DELEGATED DECISION TO DETERMINE PLANNING APPLICATIONS

Reference No:	2025/62/90344/W
Site Address:	3, Well Hill, Underbank Old Road, Holmfirth, HD9 1EG
Description:	Erection of two storey side extension (within a Conservation Area)
Recommending Officer:	Joshua Merriman

Officer Report – 2025/90344

PROJECT	SITE ADDRESS		CLIENT	
	Side Extension		Sykes	
	3 Well Hill Underbank HOLMFIRTH HD9 1EG		Date 25/11/2024	Project number 00106
	SHEET		Drawn by GB	Scale (@ A3) 1 : 100
Proposed Elevations		Checked by GB	DRAWING NUMBER A108	REV

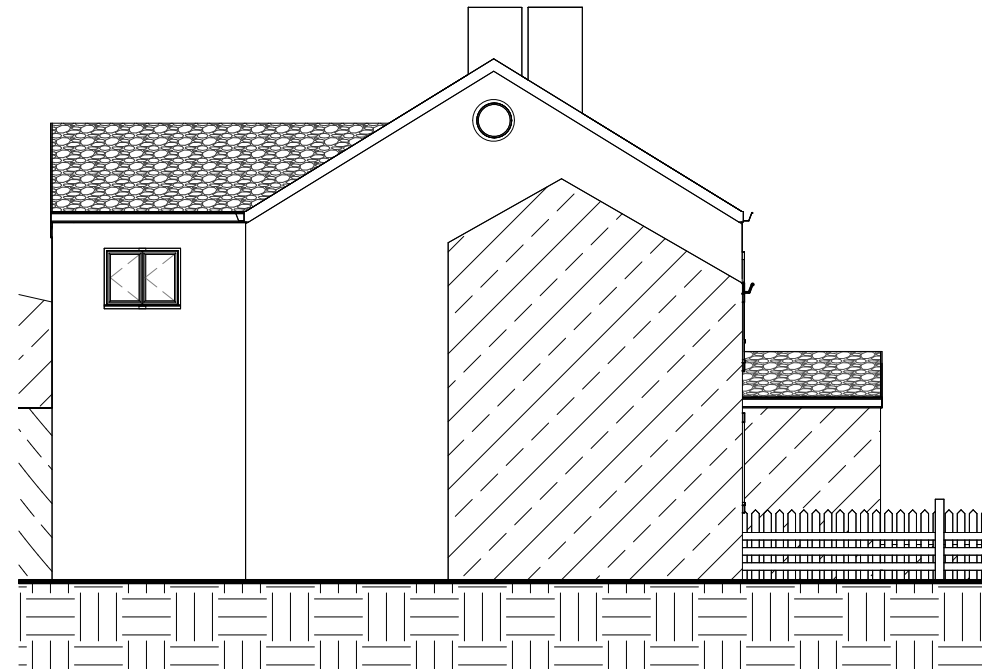
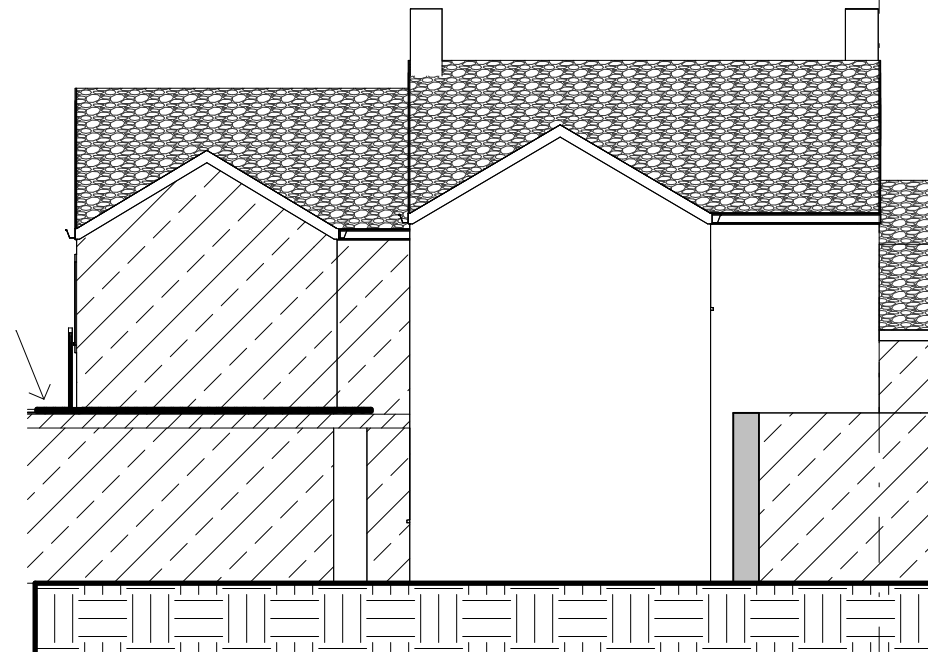
Following a consultation with KC Conservation & Design it was proposed that the applicant considered reducing the initially proposed 4 light windows in the front elevation of the upper and lower floor of the proposed extension was reduced to 3 to ensure the extension corresponded with the design of the original building. It was also recommended that the new windows should match those existing and be set back in from the face of the wall by 100-150mm. Finally, it was considered that the walls and roof should be faced in matching materials, with pointing recessed or flush and colour to match, and rainwater goods be either metal or timber, finished black.

KC Conservation & Design - Following a consultation with KC Conservation & Design it was considered that the initially proposed 4 light windows in the front elevation of the upper and lower floor of the proposed extension should be reduced to 3 to ensure the extension corresponded with the design of the original building. It was also recommended that the new windows should match those existing and be set back in from the face of the wall by 100-150mm. Finally, it was considered that the walls and roof should be faced in

Following a consultation with KC Conservation & Design it was recommended that only 3 windows were proposed in the upper and lower front elevation of the proposed extension, which has been implemented in amended plans. It was also recommended that the new windows should match those existing and be set back in from the face of the wall by 100-150mm. Finally, it was considered that the walls and roof should be faced in matching materials, with pointing recessed or flush, and colour to match, and rainwater goods be either metal or timber, finished black. In this case it is considered appropriate to condition matching materials of construction and pointing to be undertaken as part of the development.

The applicant was informed of these recommended amendments, to which plans were received detailing the use of only 3 windows in the upper and lower front elevation of the extension, all of which were set back from the face of the wall by 100-150mm, with materials used in the extension matching those of the existing building. As a result of amendments, conditions have recommended by KC Conservation & Design who advise they have no objection on this basis.

PROJECT	3 Well Hill Underbank HOLMFIRTH HD9 1EG	CLIENT		
Side Extension		Sykes		
SHEET		Date 25/11/2024	Project number 00106	Scale (@ A3) 1 : 200
		Drawn by GB	DRAWING NUMBER	
Site Parking	Checked by GB	A112	REV

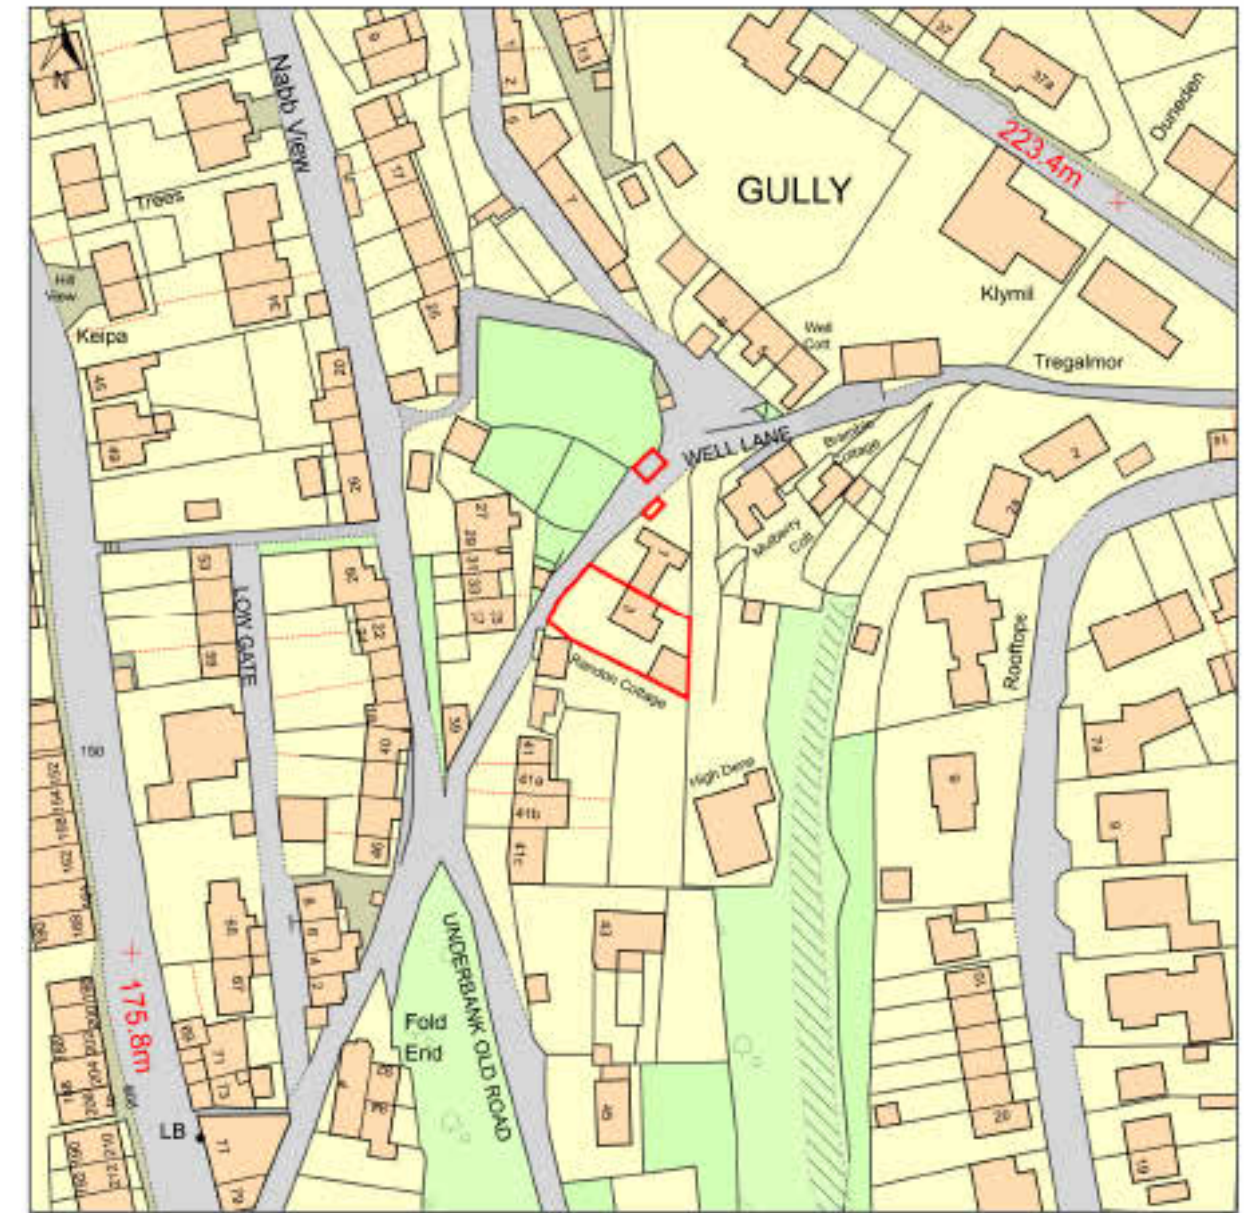
- Holme Valley Parish Council support the application, but with concern for adequate parking for a larger dwelling.

A parking plan was requested by the case officer regarding parking at the property. Following the submission of a parking plan, it clearly details the ability for two off-street parking spaces around the application site. In this case there is shared parking for the terraced row (No's 1 and 2 are now one property) on a small access off Well Hill. The submitted plans indicate that there is an additional parking space on Well Hill however it is not confirmed as to whether this is a formal arrangement within the title deeds or whether this is optional off-street parking for the area.

On-street parking within the area is constrained due to the topography of the area and also limited road width. However, the increase in bedroom provision would be to 3 no. bedrooms and therefore 2 no. off-street parking spaces are required to meet the aims of the SPD. As this has been demonstrated within the details of submission by utilising both off-street and on-street areas, it is finely balanced that this arrangement is considered acceptable.

Officer Comments: A parking plan was requested from the applicant and the scheme is deemed acceptable in terms of highway safety and parking provision.
